**Application No:** 22/01555/FUH - (Full Application (Householder))

**Location:** 29A Burton Old Road, Streethay, Lichfield, Staffordshire

**Proposal:** Demolition of conservatory and erection of a single and two storey extension to form lounge, double garage and bedroom with en suite

1 Ground Floor - Proposed  
 Scale: 1:100

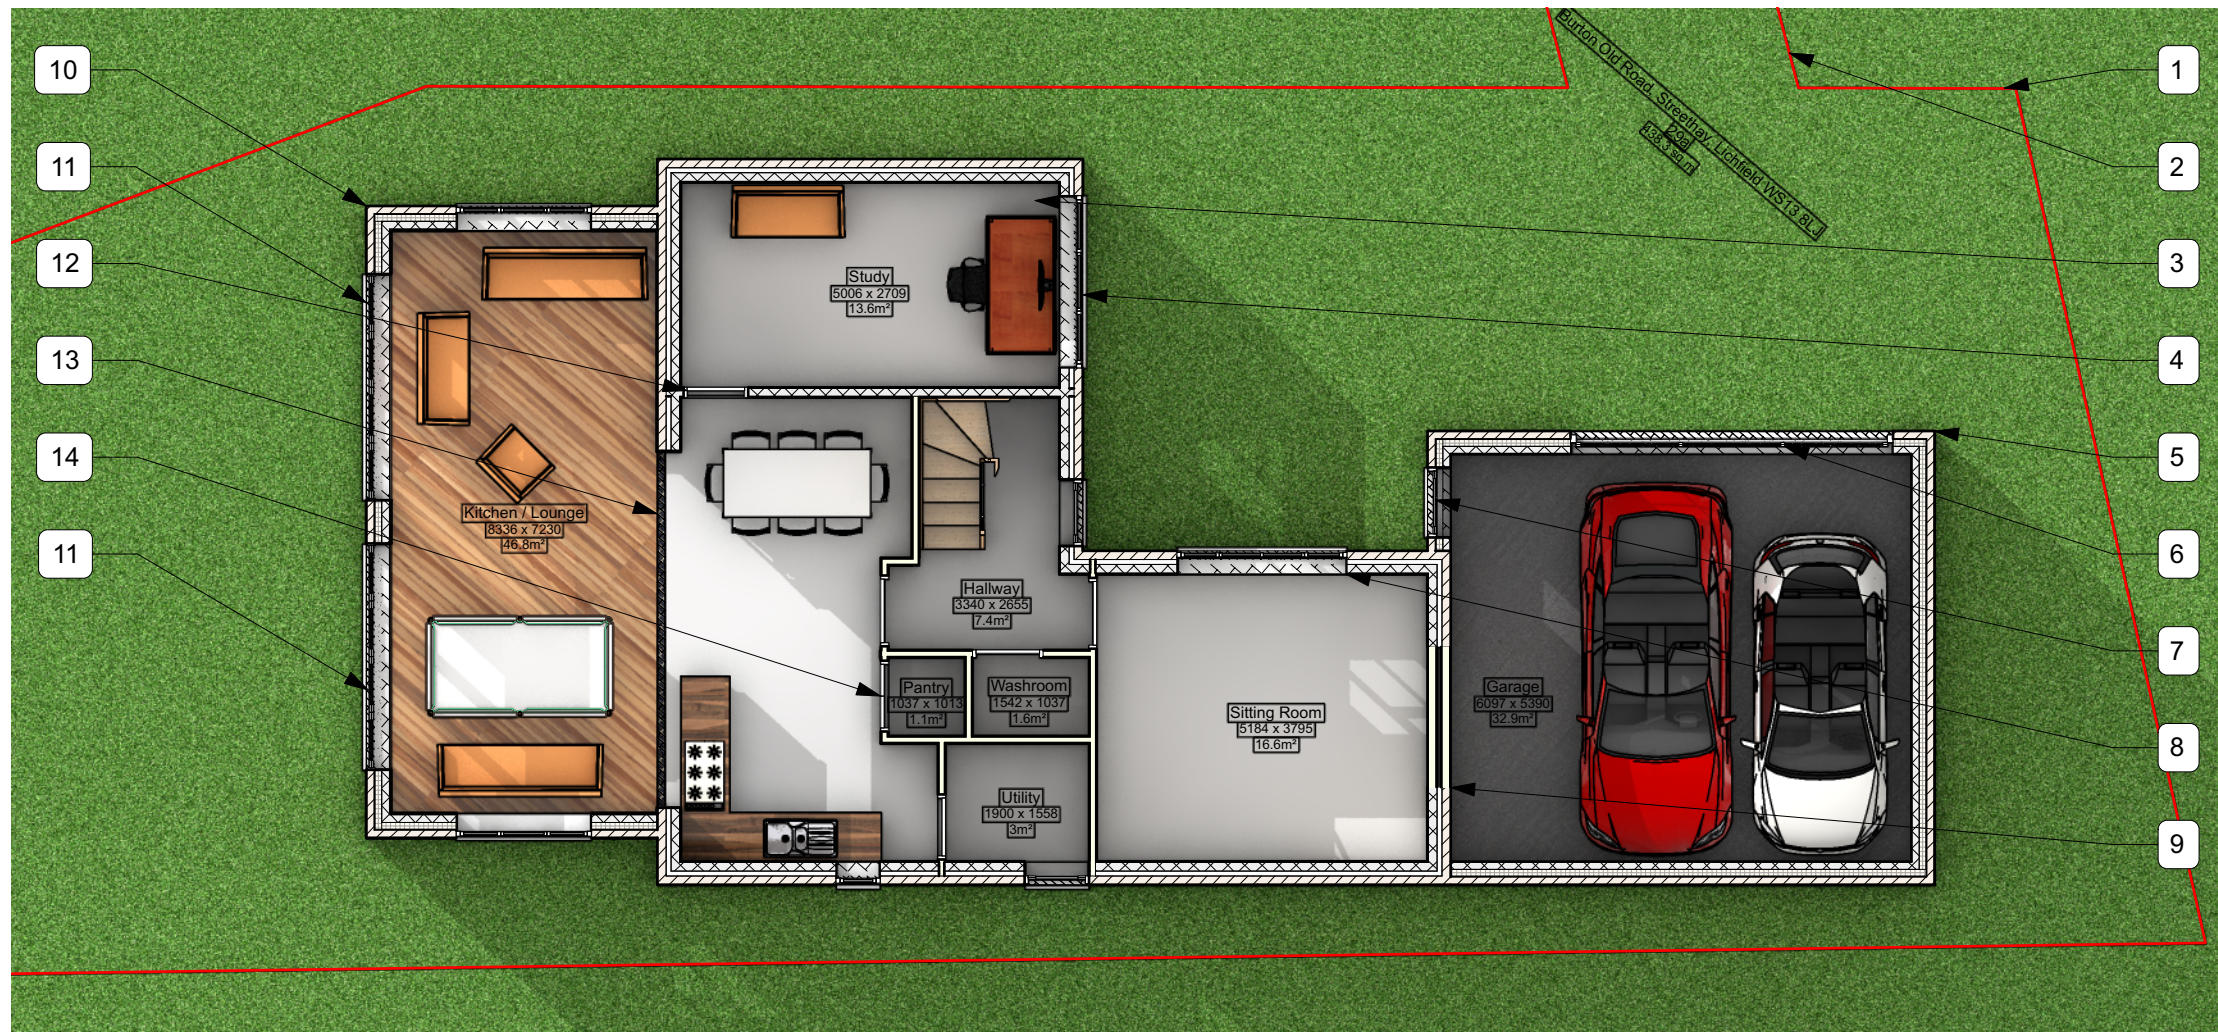
Network rail has the following comments. It is noted that the extension follows the line of the existing structure – however, that is potentially less than 3m from the railway boundary.

Network Rail **REQUIRES** that the developer includes a minimum 3 metres gap between the buildings and structures on site and the railway boundary. Less than 3m from the railway boundary to the edge of structures could result in construction and future maintenance works being undertaken on Network Rail land, and close to the railway boundary potentially impacting support zones or lineside cabling. All the works undertaken to facilitate the design and layout of the proposal should be undertaken wholly within the applicant's land ownership footprint including all foundation works. Network Rail requires a minimum 3m easement between structures on site and the railway boundary to ensure that we can maintain and renew our boundary treatments. No part of the structure should over-sail the railway boundary or discharge rainwater goods onto or toward the railway boundary.
